Subject: RE: Planning Consultation on: BN/128/19/OUT

Engineers Comments Regarding Surface Water Drainage

Site Address: Land Adjacent to Highfield House Yapton Road Barnham PO22 0AZ

Description of Works: Application for Outline Planning Permission for development of 70 bed Care Home and 14 Assisted Living Bungalows with associated car parking, landscaping and access - Departure from the Development Plan

## Yapton SUDS Layout

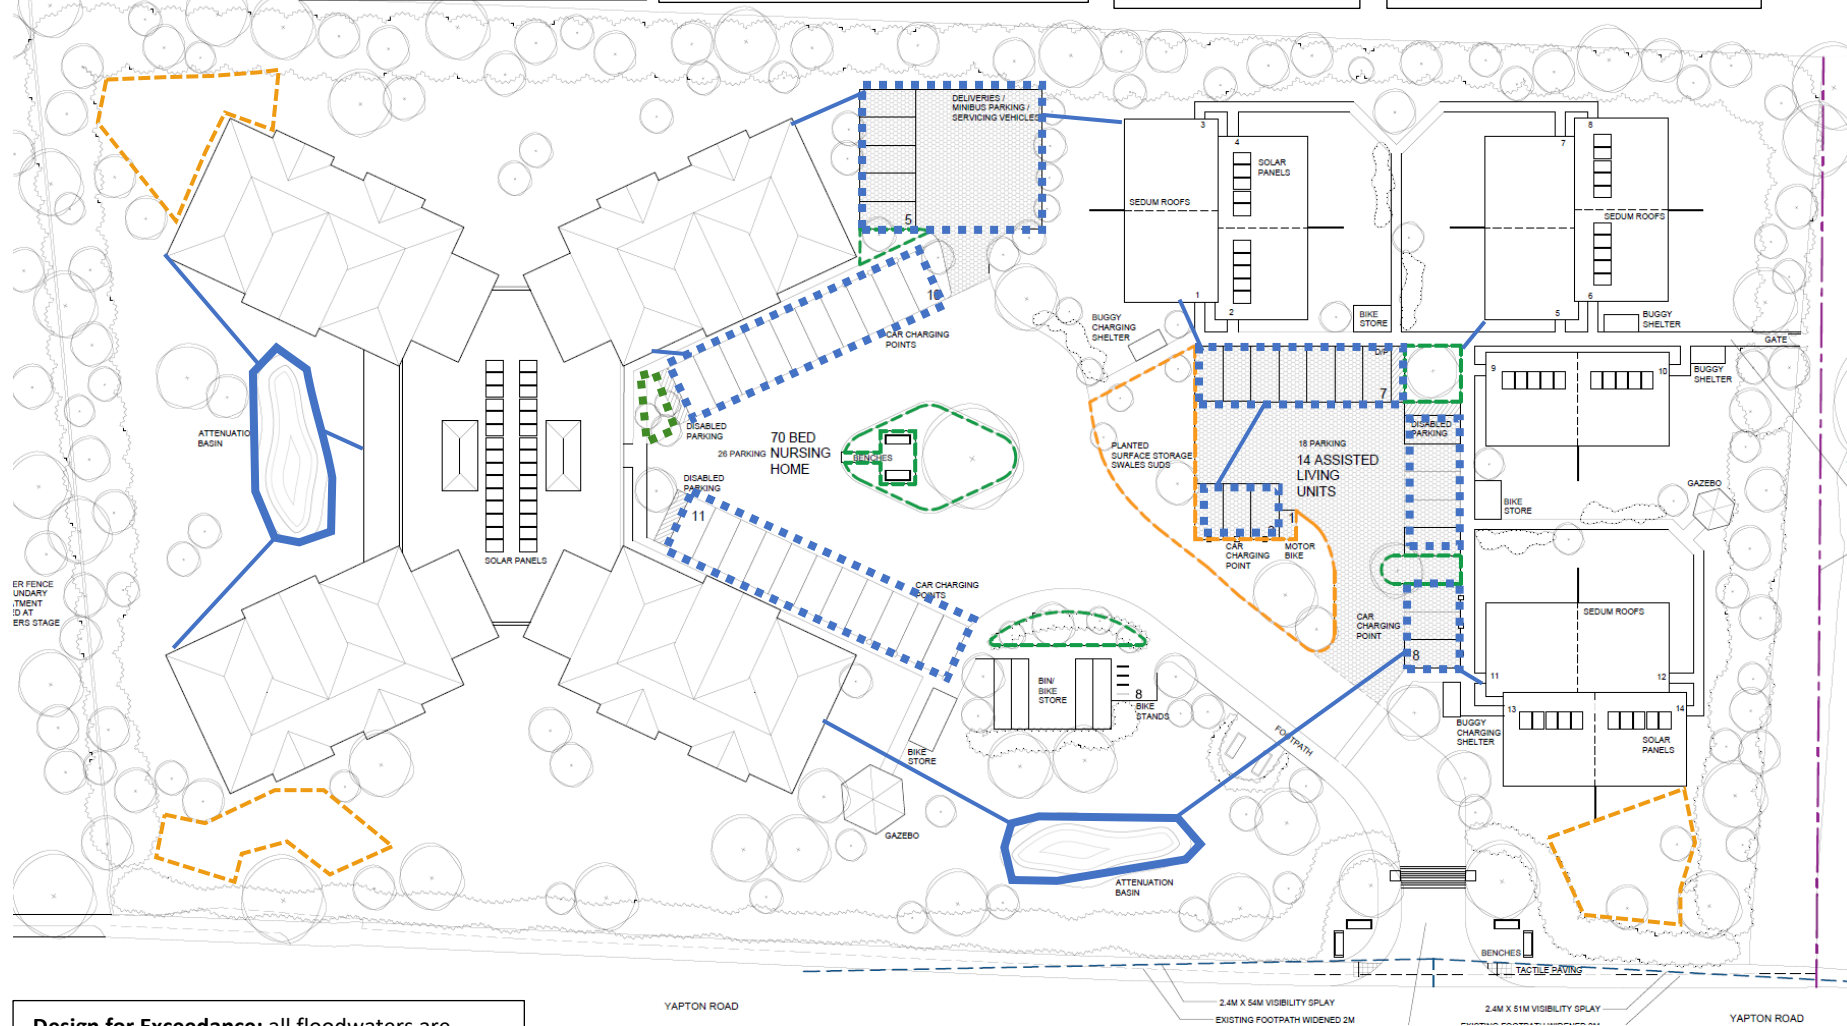
Drainage of the site could be challenging if ground conditions prove unfavourable for infiltration ,however, infiltration must be fully investigated. The applicant will need to determine peak winter groundwater levels, which will then inform winter infiltration testing (to be agreed with ourselves). The applicant is strongly urged to consider the requirements detailed in our guidance notes and check list available from the web link below.

From the drainage strategy submitted, it is unclear whether drainage ditches exist within close proximity of the site.

"Development shall not commence, other than works of site survey and investigation, until full details of the proposed surface water drainage scheme have been submitted to and approved in writing by the Local Planning Authority. The design should follow the hierarchy of preference for different types of surface water drainage disposal systems as set out in Approved Document H of the Building Regulations, and the recommendations of the SuDS Manual produced by CIRIA. Winter groundwater monitoring to establish highest annual ground water levels and winter Percolation testing to BRE 365, or similar approved, will be required to support the design of any Infiltration drainage. No building / No part of the extended building shall be occupied until the complete surface water drainage system serving the property has been implemented in accordance with the agreed details and the details so agreed shall be maintained in good working order in perpetuity."

"Infiltration rates for soakage structures are to be based on percolation tests undertaken in the winter period and at the location and depth of the proposed structures. The percolation tests must be carried out in accordance with BRE365, CIRIA R156 or a similar approved method and cater for the 1 in 10 year storm between the invert of the entry pipe to the soakaway, and the base of the structure. It must also have provision to ensure that there is capacity in the system to contain below ground level the 1 in 100 year event plus 40% on stored volumes, as an allowance for climate change. Adequate freeboard must be provided between the base of the soakaway structure and the highest recorded annual groundwater level identified in that location. Any SuDS or soakaway design must include adequate groundwater monitoring data to determine the highest winter groundwater table in support of the design. The applicant is advised to discuss the extent of groundwater monitoring with the Council's Engineers.
